Road Safety Audit Report

Incorporating
Stage 1 Completion of Preliminary Design;
Design Organisation Response to items raised.

Proposed Priority Access off Chalcraft Lane Bersted

Client:
i-Transport

APPENDIX 3
SITE ACCESS PLAN (REF: ITB14224-GA-001 REV B)

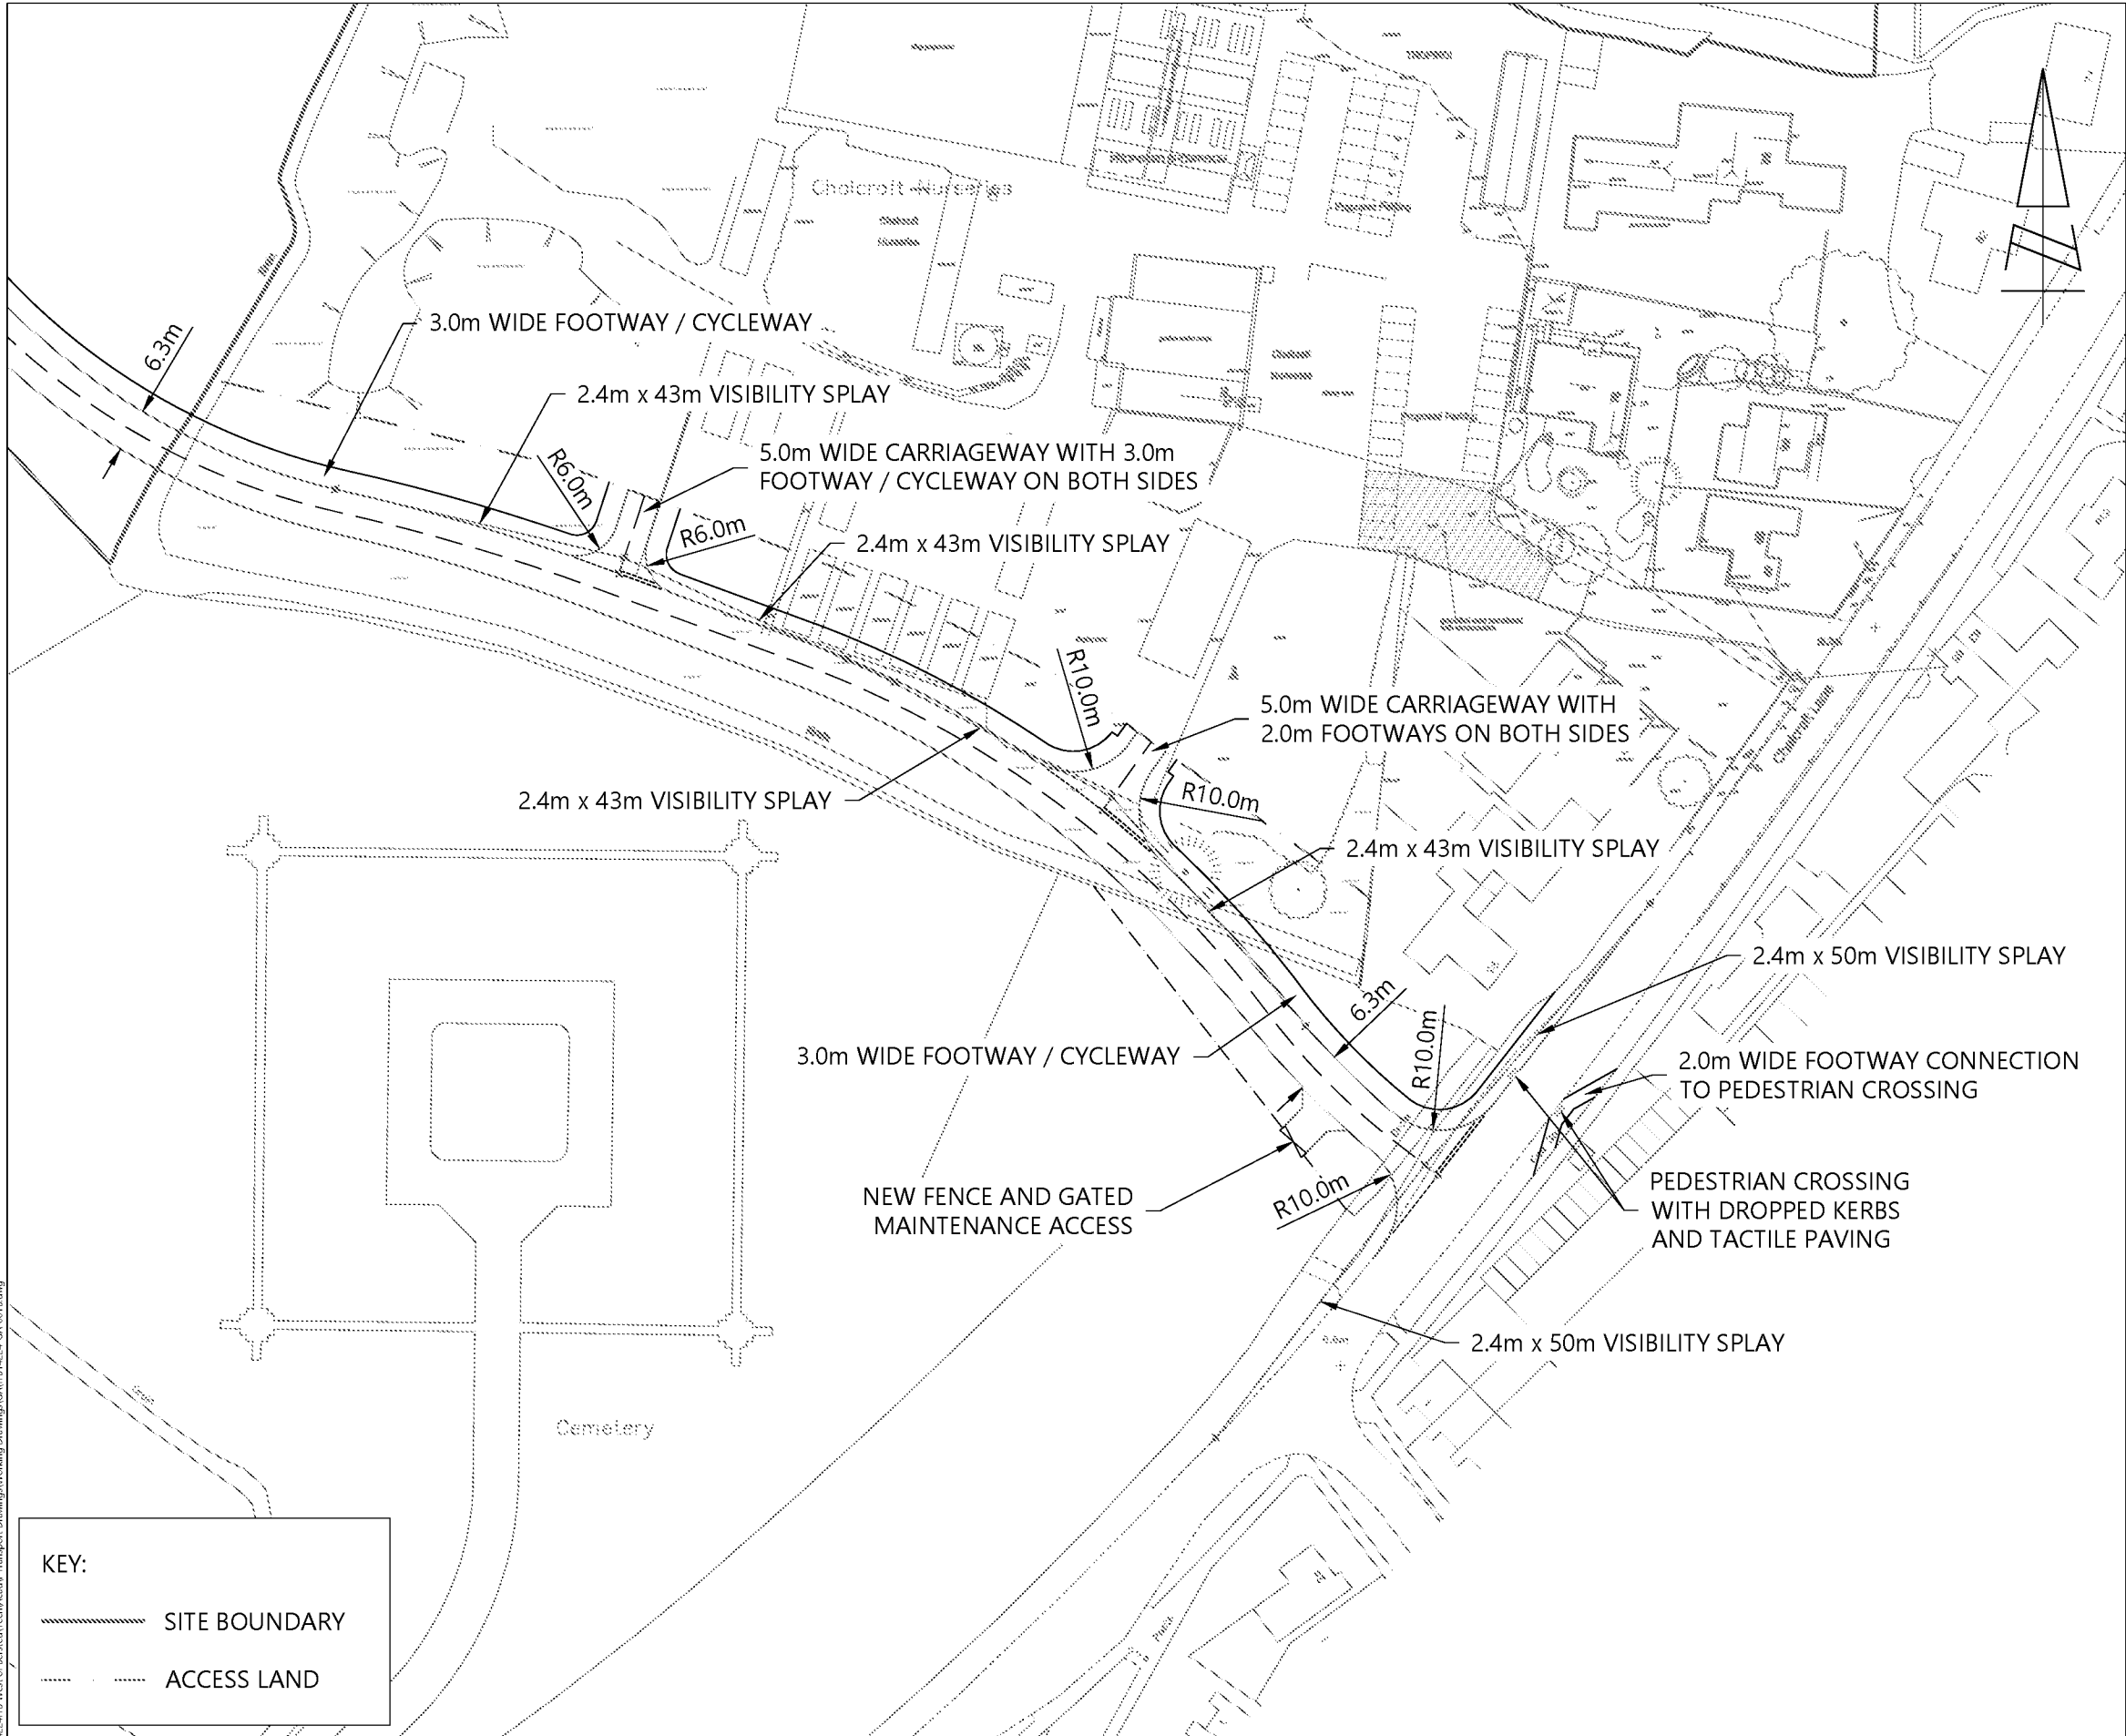
A.1	LOCAL ALIGNMENT
	<i>No Road Safety Concerns regarding LOCAL ALIGNMENT have been raised at this stage</i>
A.2	GENERAL
A.2.1	PROBLEM
Location:	Proposed access, Chalcraft Lane
Summary:	Existing road gully will be within the path of vehicles
Acc Type:	Loss of control
Chalcraft Lane benefits from a network of road gullies that provide for the drainage of surface water that accumulates on the carriageway. Following implementation of the proposed access, a pair of existing gullies will be situated within the path of a vehicle or cyclist approaching and entering the proposed access. A road gully within the path of a vehicle could give rise to loss of control type incidents especially for two wheeled vehicles and vehicles undertaking a braking manoeuvre.	
RECOMMENDATION:	
It is recommended that the gullies are relocated and an adequate surface water drainage network is provided.	
Location Plan:  	
DESIGN ORGANISATION RESPONSE provided by i-Transport on the 8th September 2020 following formal issue of this Stage 1 Road Safety Audit on the 7th September 2020

Accepted – to be addressed as part of the S278 Detailed Design.	
A.2.2	PROBLEM
Location:	Proposed access
Summary:	A ditch and number of outlets / headwalls are present within the area of the works
Acc Type:	Vehicle loss of control
A drainage ditch is present along the northern side of Chalcraft Lane that accommodates a number of headwalls and outlets from the network of road gullies that are situated along the channel line and allow surface water for the drainage of surface water. The proposals provide a priority junction

that allows access to a 6.3-metre wide carriageway that accommodates a 3-metre wide shared footway / cycleway along the northern side, which will have an impact on the ditch and outlets that are present. Inadequate surface water drainage could result in ponding and loss of control incidents.

It is recommended that measures are provided to ensure that surface water drains adequately

Location: Proposed access, northern verge of Chalcraft Lane

Summary: Foliage within the verge to the south of the proposed access restricts visibility

Chalcraft Lane forms part of a primary route between North Bersted and Aldwick and is subject to a 30mph speed limit. The proposals include the provision of a simple priority access off the northern side of the carriageway from which the scheme drawing illustrates that 2.4 x 50 metre visibility splays are achievable in accordance with the 30mph speed limit of the road. However, the verge along the southern side of the proposed access is overgrown with foliage encroaching the carriageway in places. The tree canopies and vegetation will restrict visibility to and from a vehicle exiting the proposed simple priority access which could give rise to side impact or rear end collision when a vehicle proceeds when it is not safe to do so.

It is recommended that the appropriate visibility splays are maintained clear and free of obstructions.

Location: Proposed crossing point, southern footway Chalcraft Lane

Summary: Existing street lighting column will become an obstruction to pedestrians

Chalcraft Lane benefits from street lighting with a number of street lighting columns located within the existing verge to the east of the carriageway. The proposals provide a 2.0-metre footway link from the existing footway to a proposed uncontrolled crossing point on Chalcraft Lane. The Audit Team observed that an existing streetlight column may be situated at this location which will be located within the proposed footway and be an obstruction to pedestrians. Such an obstruction could be struck by a pedestrian or force one to enter the carriageway suddenly raising the risk of vehicle collisions with pedestrians as well as trips and falls.

It is recommended that the street lighting column is relocated out of the footway

Summary: The verge to the east of the carriageway forms an embankment

Chalcraft Lane is subject to a 30mph speed limit and accommodates a footway along each side of the carriageway with the footway to the east beyond a verge and set at a higher level. The scheme drawings identify that an uncontrolled crossing point is to be provided to the north of the access. Due to the gradient of the verge on the eastern side of Chalcraft Lane, the proposals

provide an angled 2.0-metre footway link from the existing footway to the crossing point; however, scheme drawings do not detail the effect of the likely crossfall towards the carriageway. As such, a user of a wheeled device such as a child on a scooter or wheelchair user, approaching the crossing point may not become aware of the crossfall combined with the steep incline towards the carriageway and could inadvertently lose control and continue into the path of an oncoming vehicle.

It is recommended that the crossing point is set at a maximum gradient of 1 in 12 down to the carriageway.

Location: Proposed footway / cycleway, northern footway

Summary: Services covers will be an obstruction

Chalcraft Lane accommodates a number of utility covers within the existing footway, verge, and carriageway. The proposals include the provision of a priority access off the western side of Chalcraft Lane that accommodates a 3.0-metre footway cycleway along the northern radius which ties into the local pedestrian network. The scheme stops up an existing parking bay situated along the western side of the Chalcraft Lane carriageway where a number of the utility covers are present and will be located within the footway following the works. Raised or sunken utility covers along a pedestrian desire line, will be an obstruction and trip hazard.

It is recommended that service covers are adjusted or relocated accordingly.

Accepted – to be addressed as part of the S278 Detailed Design.

Location Plan:  	
DESIGN ORGANISATION RESPONSE provided by i-Transport on the 8th September 2020 following formal issue of this Stage 1 Road Safety Audit on the 7th September 2020	
Accepted – vegetation encroaching within the visibility splay to be cut back as part of the site access work. On-going maintenance of vegetation within the highway is a statutory responsibility of the local highway authority.	
A.4	WALKING CYCLING AND HORSE RIDING
A.4.1	PROBLEM
Location:	Chalcraft Lane and Proposed access road
Summary:	Full height kerbs will be an obstruction to pedestrians especially the mobility impaired
Acc Type:	Vehicle pedestrian and pedestrian trips and falls
Ffairfach Close provides access to the existing commercial development off Chalcraft Lane where pedestrians are required to walk in the carriageway. The proposals provide a spine road accessed off a simple priority junction with Chalcraft Lane and accommodates two priority accesses off the northern side that are to serve a commercial development and 20 dwellings. A shared footway / cycleway is provided along the northern side of the proposed carriageway that allows cyclists and pedestrians to join the existing footway along the northern side of Chalcraft Lane; however, the scheme drawings do not identify that dropped kerbs are to be provided where users are required to cross the proposed accesses. Whilst full height kerbs will become an obstruction to pedestrians particularly the mobility impaired or those walking with buggies and children on a scooter, the lack of a tactile warning could result in a visually impaired pedestrian entering the carriageway when it is not safe to do so which raises the risk of a vehicle-pedestrian collision.

Location Plan:  	
DESIGN ORGANISATION RESPONSE provided by i-Transport on the 8th September 2020 following formal issue of this Stage 1 Road Safety Audit on the 7th September 2020	
Accepted – design amended to incorporate tactile paving and dropped kerbs (see drawing ITB14224-GA-001 Rev C).	
A.4.2	PROBLEM
Location:	Proposed footway / cycleway, northern footway
Summary:	Visually impaired pedestrians could step into the path of a cyclist without warning
Acc Type:	Cyclist-pedestrian collisions
Chalcraft Lane is subject to a 30mph speed limit and accommodates a footway along each side of the carriageway. The proposals provide a 3.0-metre shared footway cycleway along the northern side of the proposed access carriageway that wraps around the corner radius to meet the existing footway of Chalcraft Lane. The scheme drawings illustrate that the existing parking bay is to be stopped up and a dropped kerb crossing point with tactile paving provided to allow access to the footway on the eastern side of Chalcraft Lane; however, no measures are provided to highlight the transition between the existing footways and proposed shared facility where cyclists are likely to be observed. As such, pedestrians particularly the visually impaired, could step into the path of a cyclist or a cyclist could continue on the footway, raising the risk of a cyclist-pedestrian collision.

Accepted – drawing has been amended to incorporate signing and corduroy paving to denote change of use.

Accepted – crossing point has been relocated as to avoid conflict with lighting column (see drawing ITB14224-001 Rev C).

Accepted – to be addressed as part of the S278 Detailed Design.

Location Plan: 2.4m x 43m VISIBILITY SPLAY  	
DESIGN ORGANISATION RESPONSE provided by i-Transport on the 8th September 2020 following formal issue of this Stage 1 Road Safety Audit on the 7th September 2020	
Accepted – to be addressed as part of the S278 Detailed Design.	
A.5	ROAD SIGNS, CARRIAGEWAY MARKINGS AND LIGHTING
	<i>No Road Safety Concerns regarding ROAD SIGNS, CARRIAGEWAY MARKINGS AND LIGHTING have been raised at this stage</i>
